**KIRKLEES METROPOLITAN COUNCIL
INVESTMENT & REGENERATION SERVICE**

**DELEGATED DECISION TO DETERMINE PLANNING APPLICATIONS TO
CARRY OUT DEVELOPMENT WITHOUT COMPLIANCE WITH PLANNING
CONDITIONS PREVIOUSLY ATTACHED**

Reference No:	2025/70/91604/W
Site Address:	Huddersfield Bus Station, Upperhead Row, Huddersfield, HD1 2JN
Description:	Variation condition 2 (plans) on previous permission 2024/92302 for refurbishment comprising (phase 1): facade improvements including Henry Street entrance; replacement shop fronts; alterations to external bus apron; extension and alterations to existing barrier within the bus alighting lane adjacent to Henry Street; (phase 2): new entrance canopy; public realm improvements; cycle hub; facade improvements including replacement shop fronts
Recommending Officer:	Liz Chippendale

Application: 2025/91604

P1 Proposed Kirklees Frontage Plan
Scale: 1 : 100

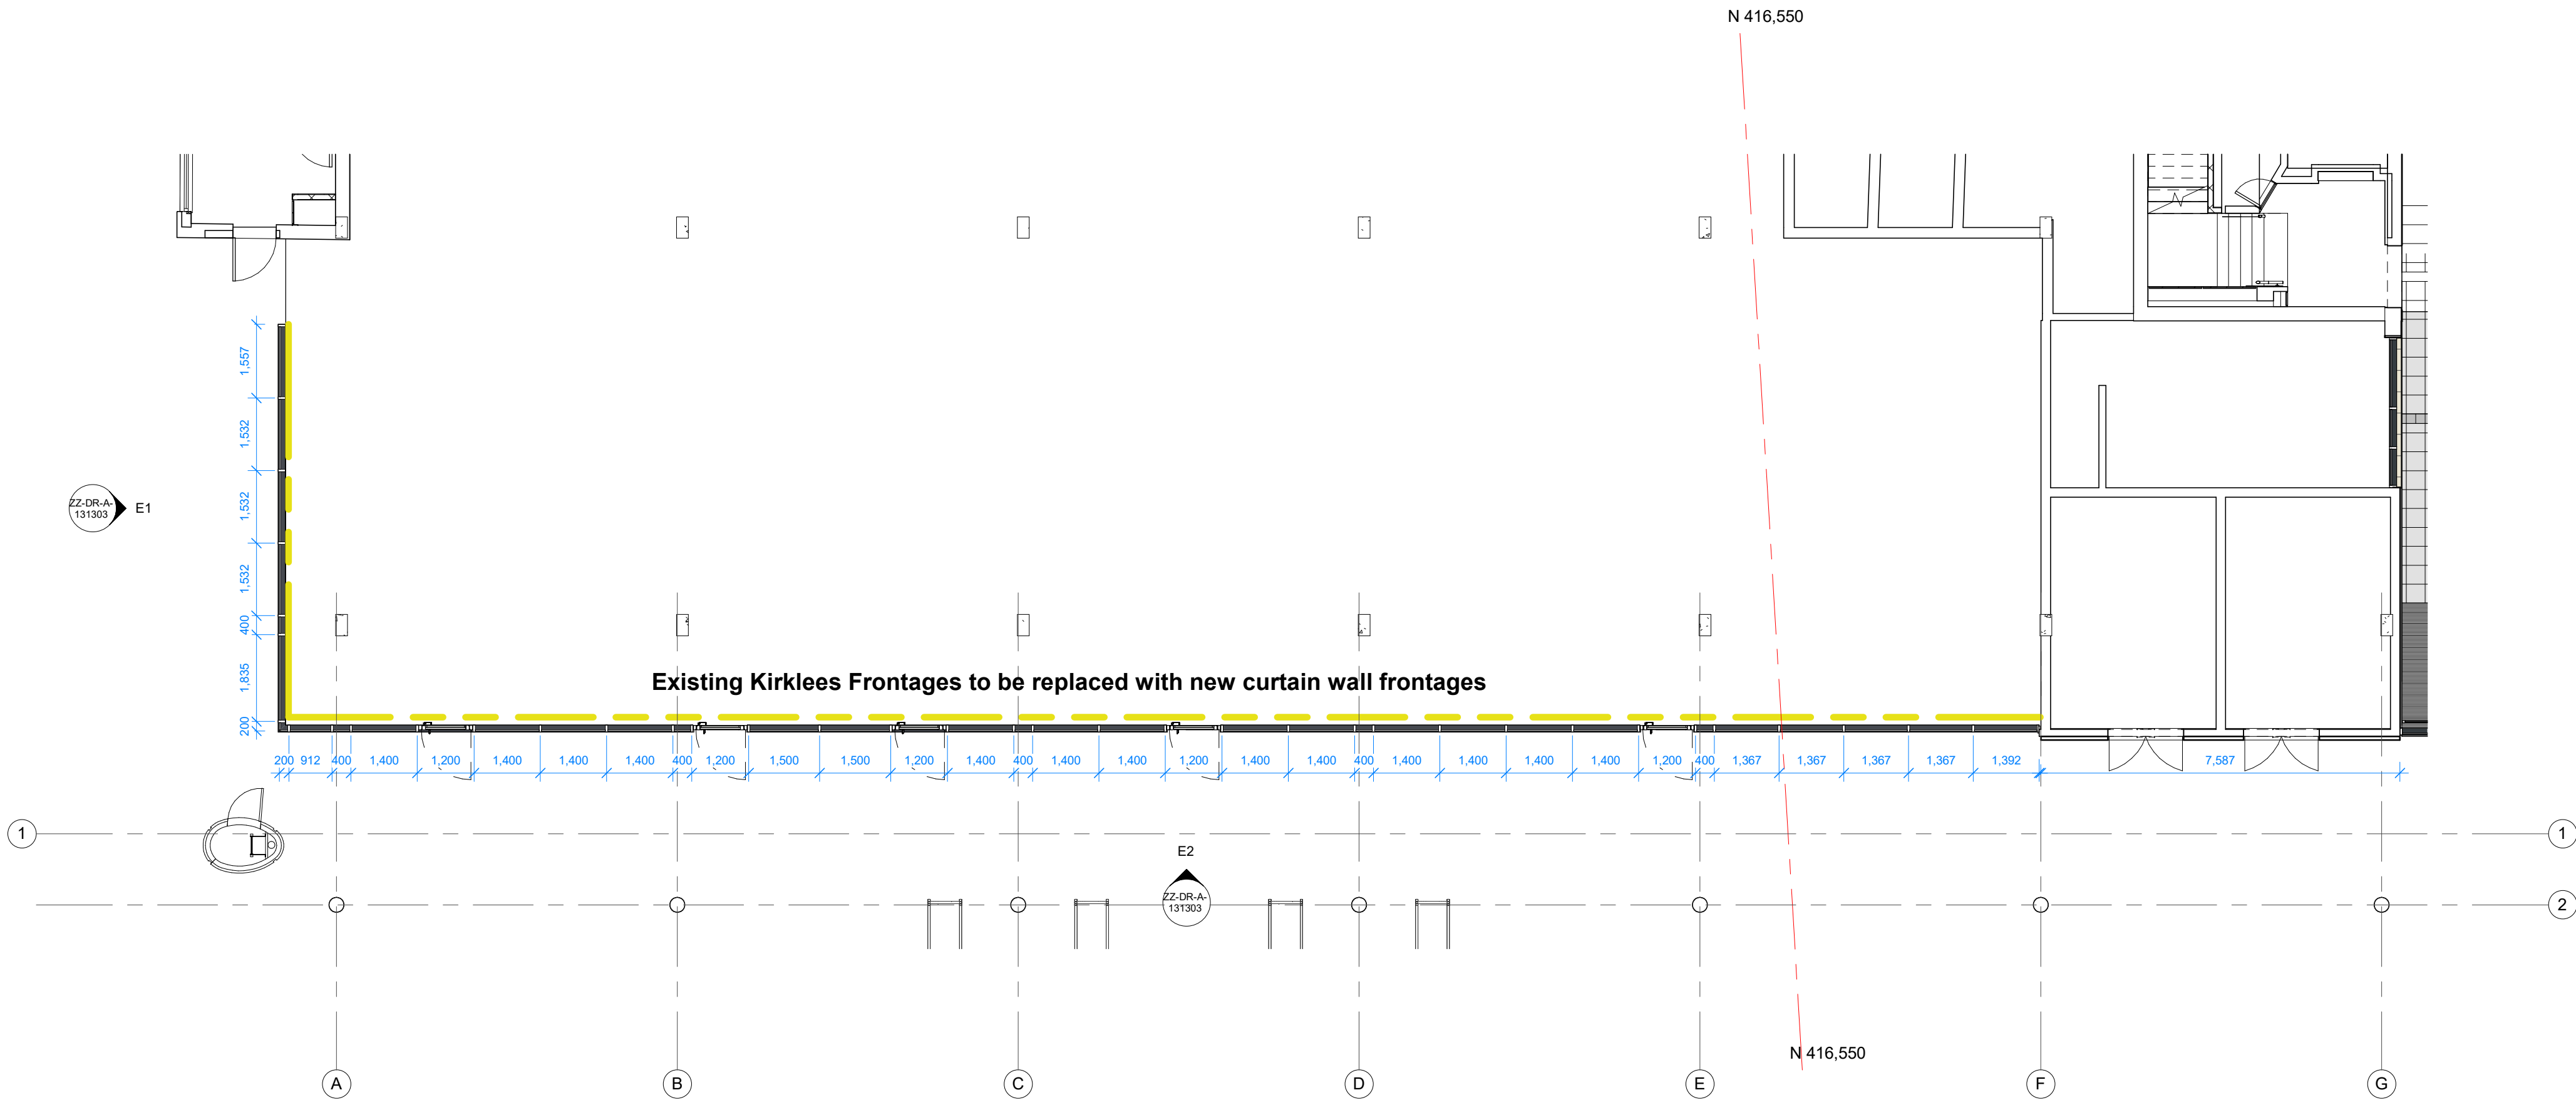
Description of Change 1: Following a Value Engineering exercise the overall size of the canopy has been reduced from 915 m² to 545 m², which included adjustments to the canopy profile.

The previously approved curved canopy will be reduced to project approximately 7.7m at its widest point the eastern elevation, sited closest to the Listed Buildings. There will be some degree of impact on the Listed Buildings, however, officer's consider this to be of less impact than the originally approved design. This is not to be a significant level of impact on the setting of the Listed Buildings and there would be a minor to no impact on the setting of the Conservation Area.

The proposed amended canopy design would reduce the projection of the canopy compared to that originally approved. As such, the works are anticipated to result in a lower impact compared to that considered acceptable during the original application, with regards to overbearing, overshadowing or loss of privacy.

The minimum separation distance between the new works and neighbouring dwellings on Upperhead Row is increased from 7.9m to 12.8m, compared to the original canopy, The proposed canopy is a low prominence structure that

34. Notwithstanding condition 2, the hereby approved entrance canopy and cycle storage facilities shall be implemented in accordance with plans ref.

202335-SGP-ZZ-ZZ-DR-A- 131301 rev. P09 and 202335-SGP-ZZ-ZZ-DR-A-A-13000 rev P14.
